GSA Planning

142-150 Narrow Neck Road Katoomba – State Significant Development proposal via the Housing Delivery Authority pathway.

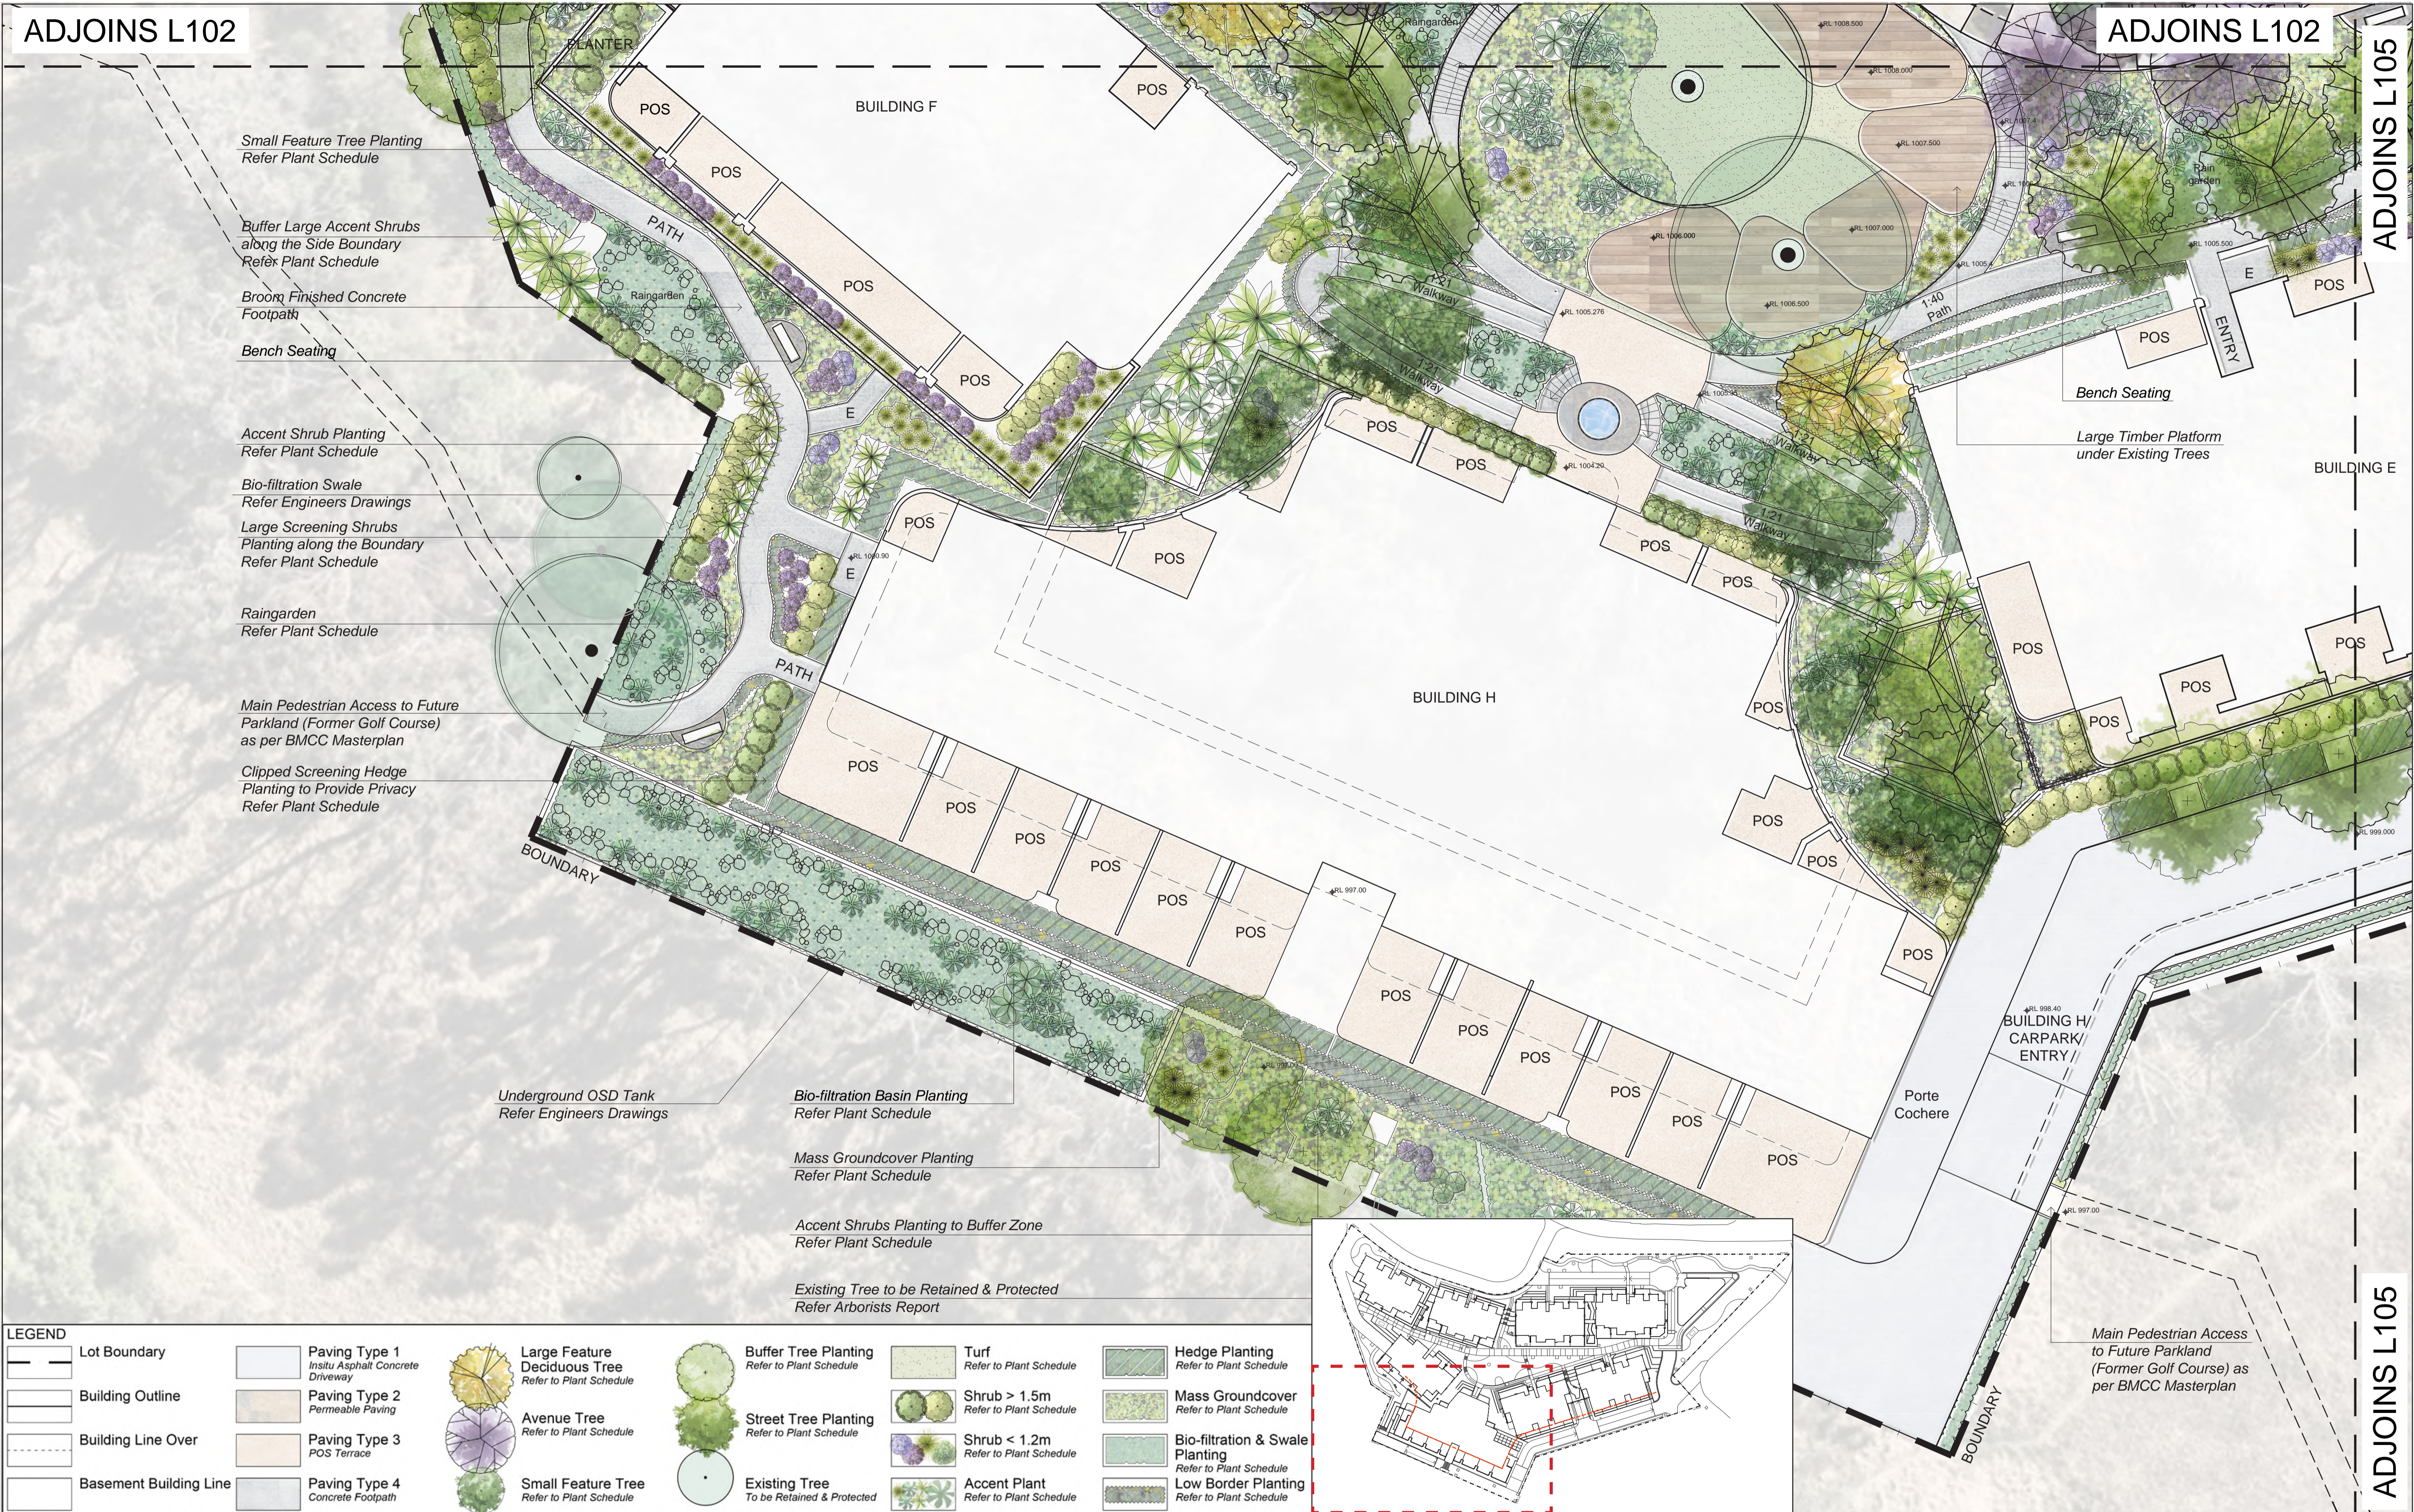
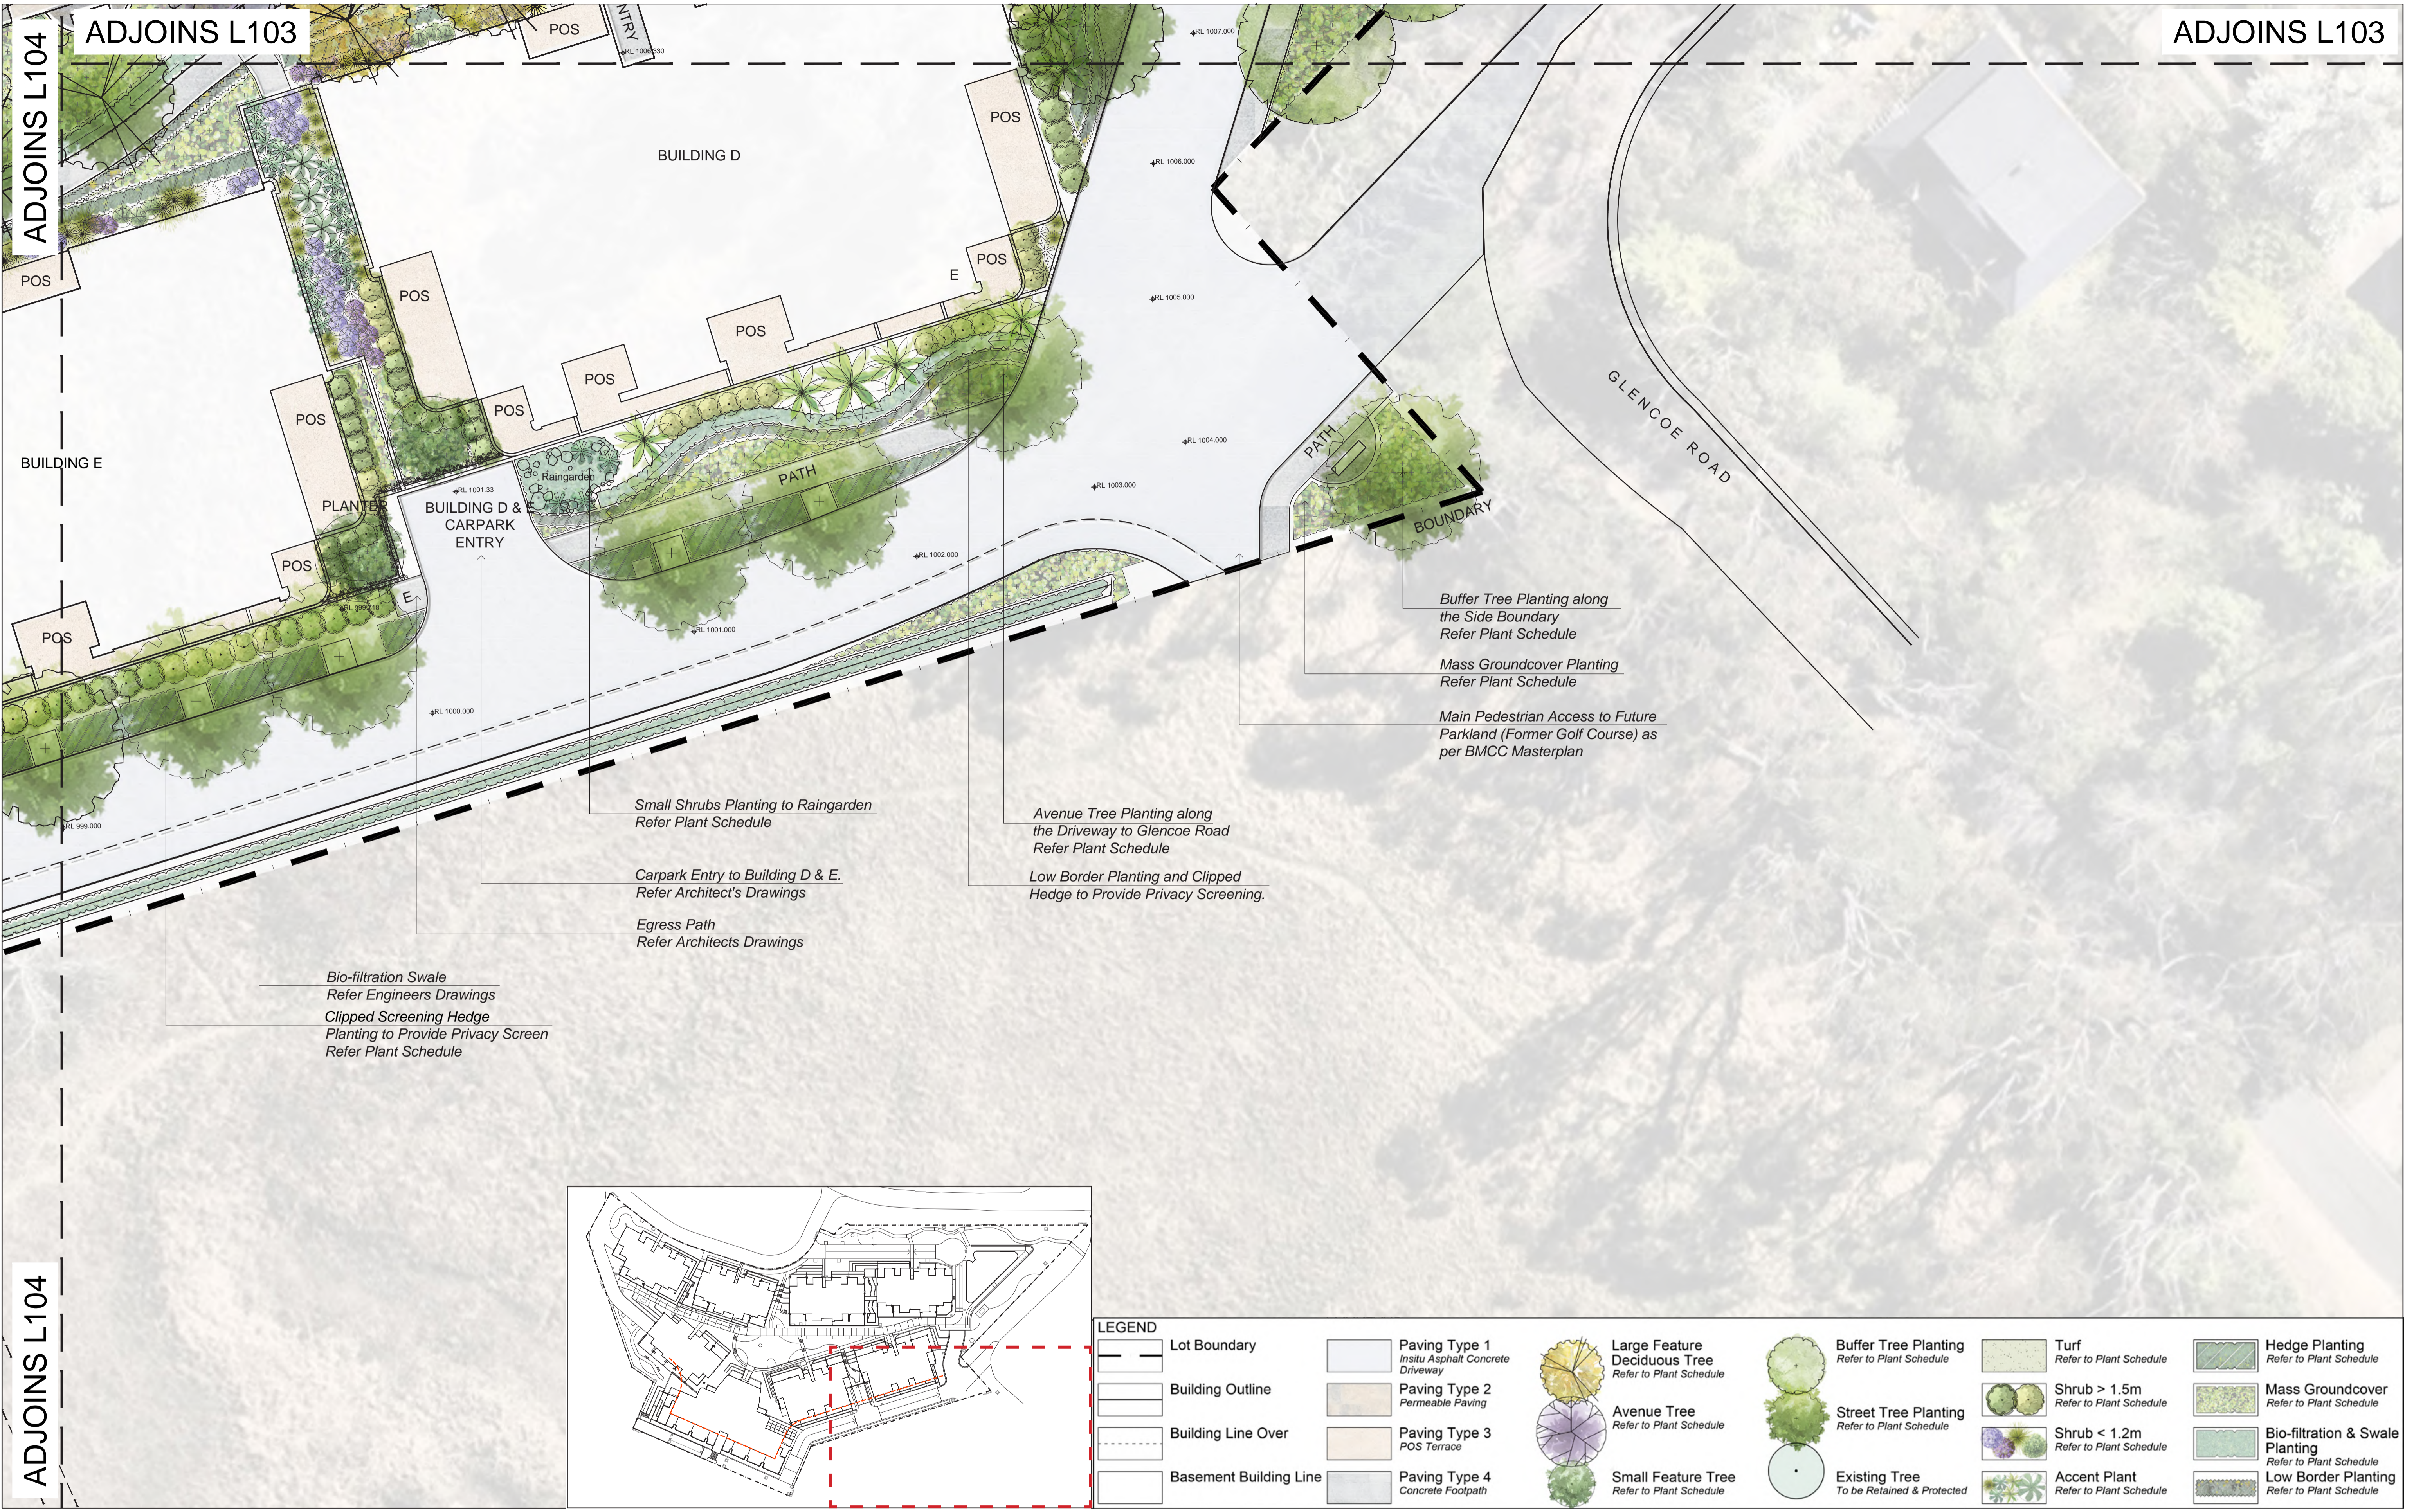
It appears that the stormwater management proposal includes a small OSD tank and nominal rain gardens, but that stormwater runoff will leave the site and be directed towards the adjoining Council land, and into existing water bodies. This is not an acceptable proposal.

Stormwater must be managed within the site, and being located within the Sydney Drinking Water Catchment, must achieve a neutral or beneficial outcome on stormwater quality. This has not been demonstrated in the documentation we have received.

We have also been advised by Water NSW that Narrow Neck Road has a short flow path into Warragamba Dam and therefore, careful consideration of the management of stormwater quality is essential and must be demonstrated. The inclusion of a small OSD device and limited rain gardens within the site, on face value, could not adequately cater for stormwater volumes from what will now be, a largely impervious site. It is not acceptable to direct stormwater into the Council's property, as part of the stormwater management for the development.
